Project Name: * R-5014-Widening of SR1217 from dead end to US158

Subject: **Request for Minor Modification of the CAMA Major Development Permit** for the widening of SR 1217 (Colington Road) from Dead End to US 158 (Croatan Highway) in Dare County, North Carolina; TIP Project R-5014, Federal Aid Project No. STP-1217(6); Debit \$100 from WBS Element 41162.1.1

Reference: CAMA Major Development Permit #125-18 issued November 5, 2018

The NCDOT is requesting a Minor Modification for CAMA Major Development Permit #125-18.

PROJECT REFERENCE NO. R-5014	SHEET NO. 14
R/W SHEET NO.	
ROADWAY DESIGN 8/31/2021 ENGINEER	HYDRAULICS ENGINEER 4/1/2021
SEAL 017265 STATE ENGINEER STEVE ANTHONY DRUM	SEAL 39785 STATE ENGINEER CRAIG A. FREEMAN JR.

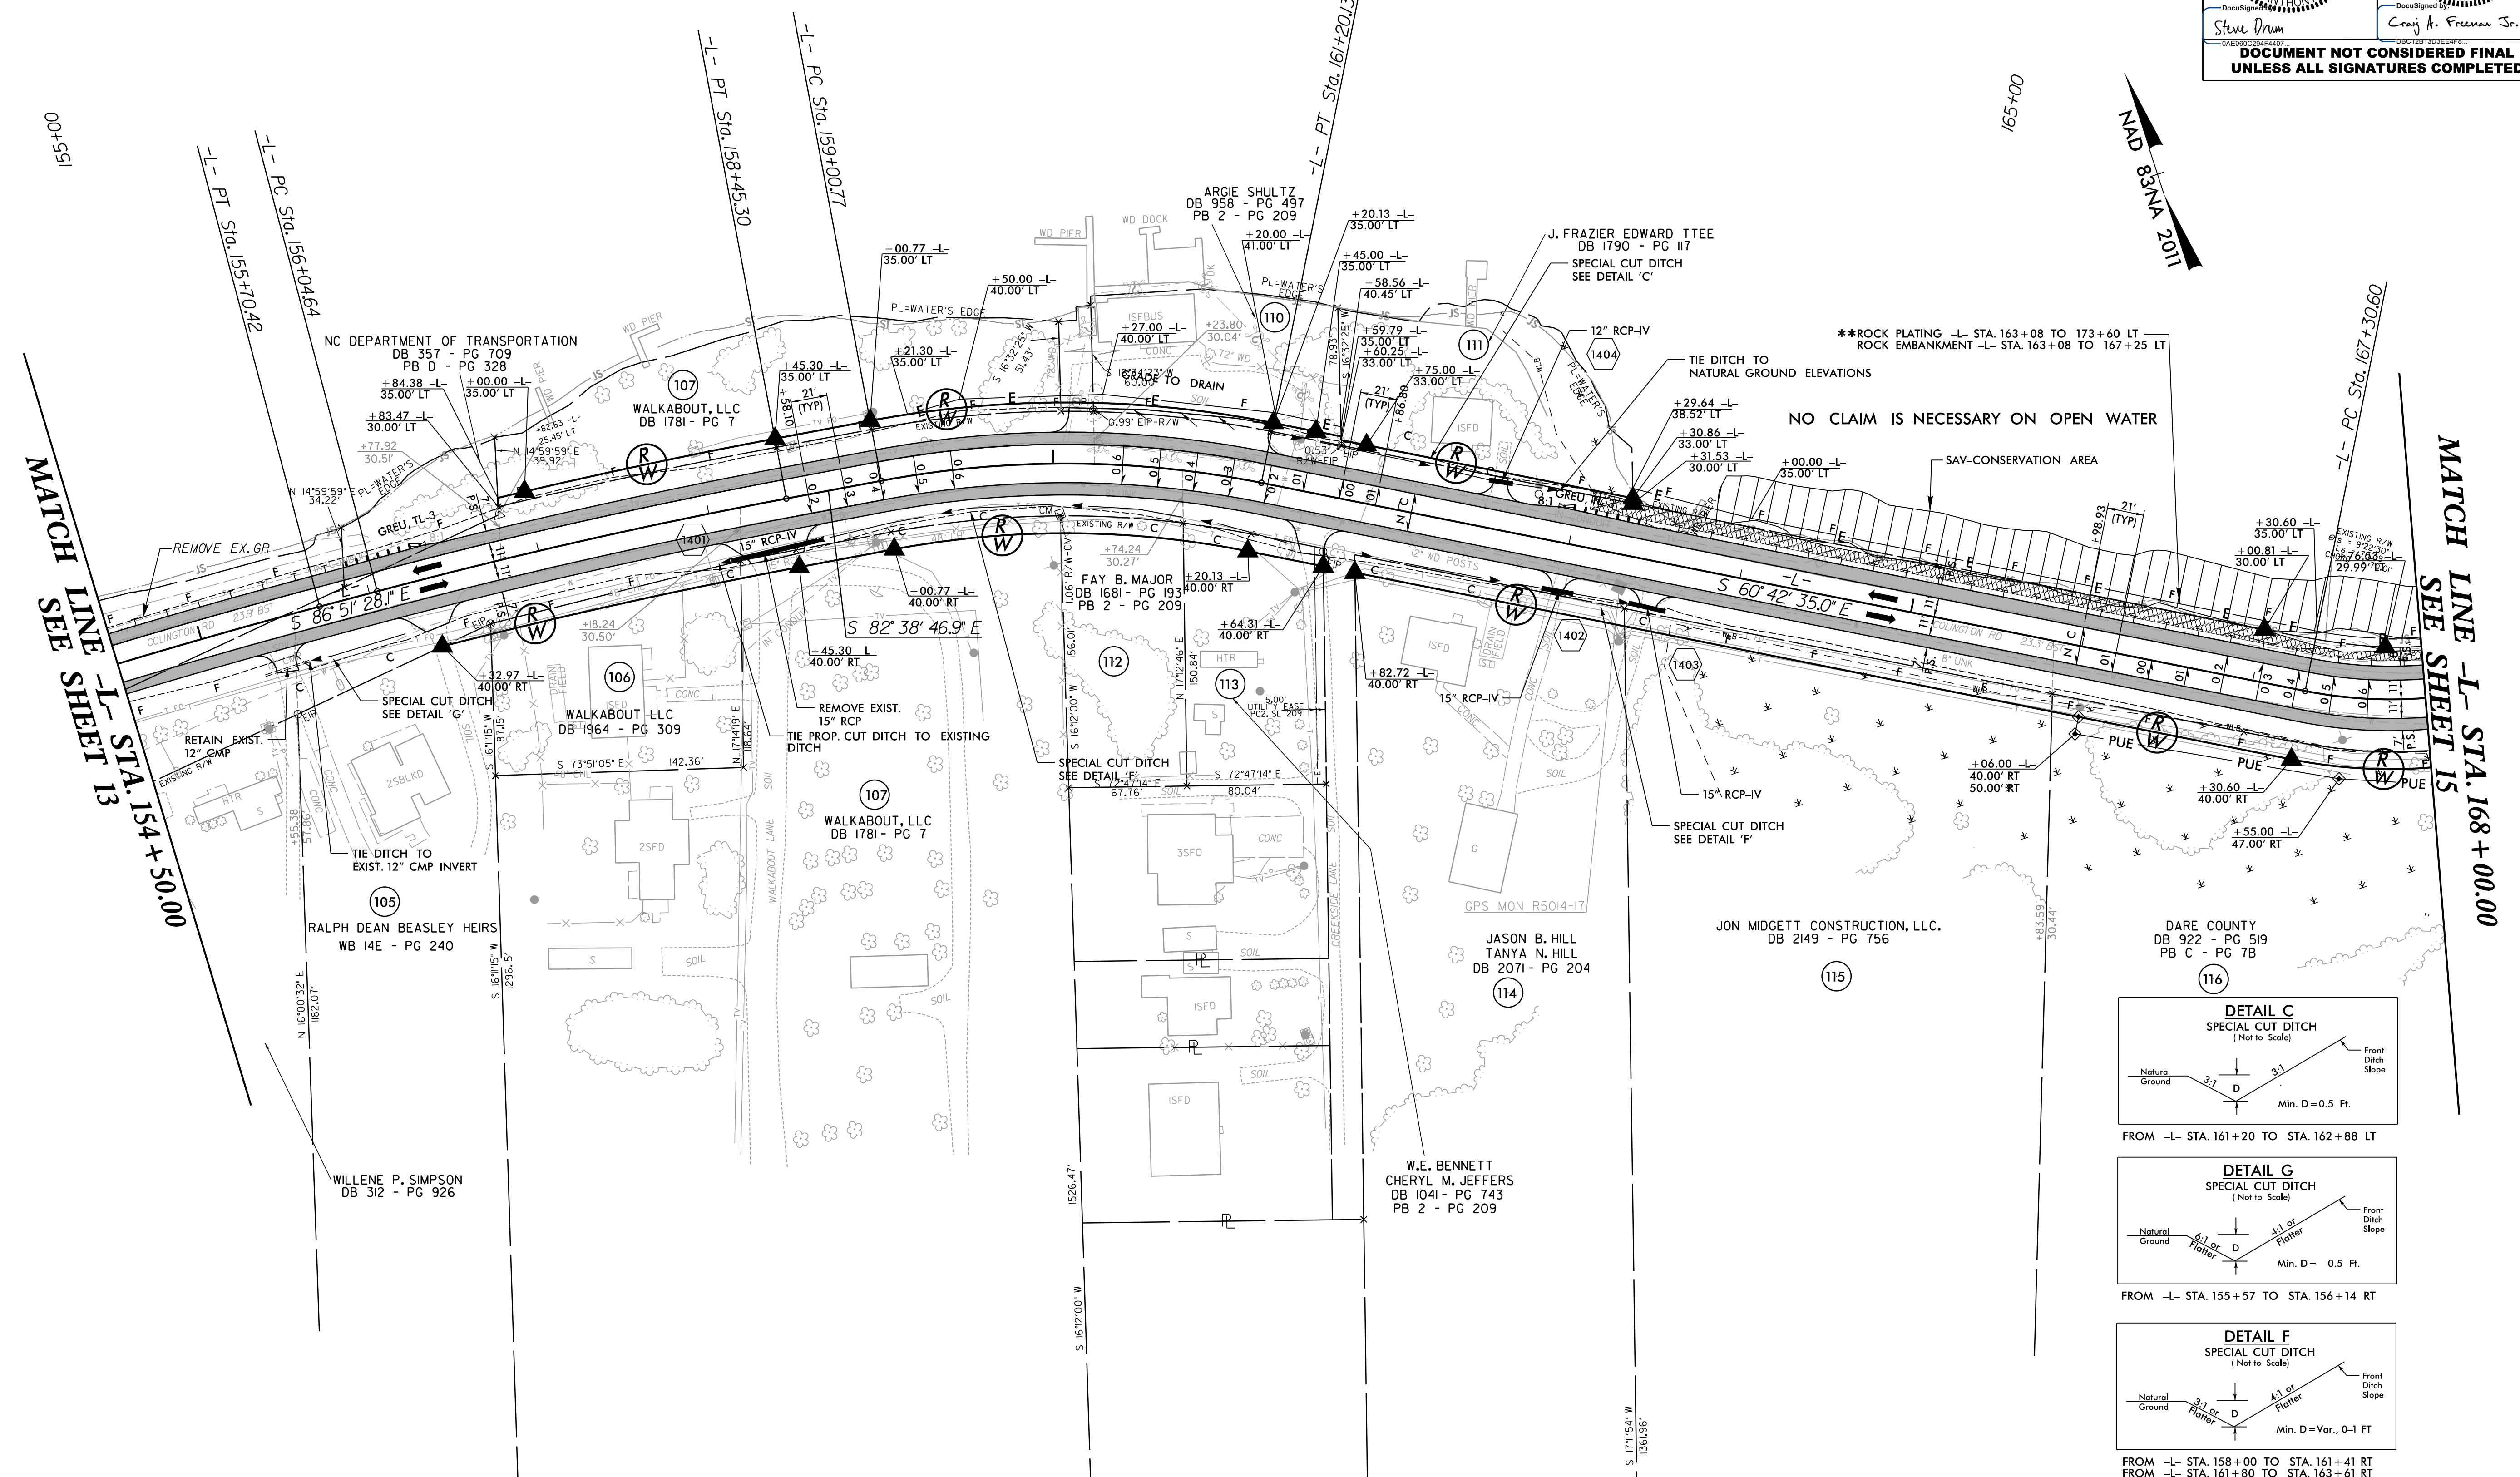
Additionally, after further investigation, it was determined that riprap placed in areas sensitive to adverse storm events had been sized improperly. A change was made to the plan drawings from the smaller Class I rock to a larger Class II. The Class II was determined to be sufficient to not shift or move during adverse weather. The above listed sites also include an increase in rock size. These sites are now depicted on the drawings as Rock Plating. The change resulted in no additional impact. Below is a list of sites where the rock size was changed only:

Sites 16 & 18 163+08 to 173+60 LT, rock embankment / rock plating
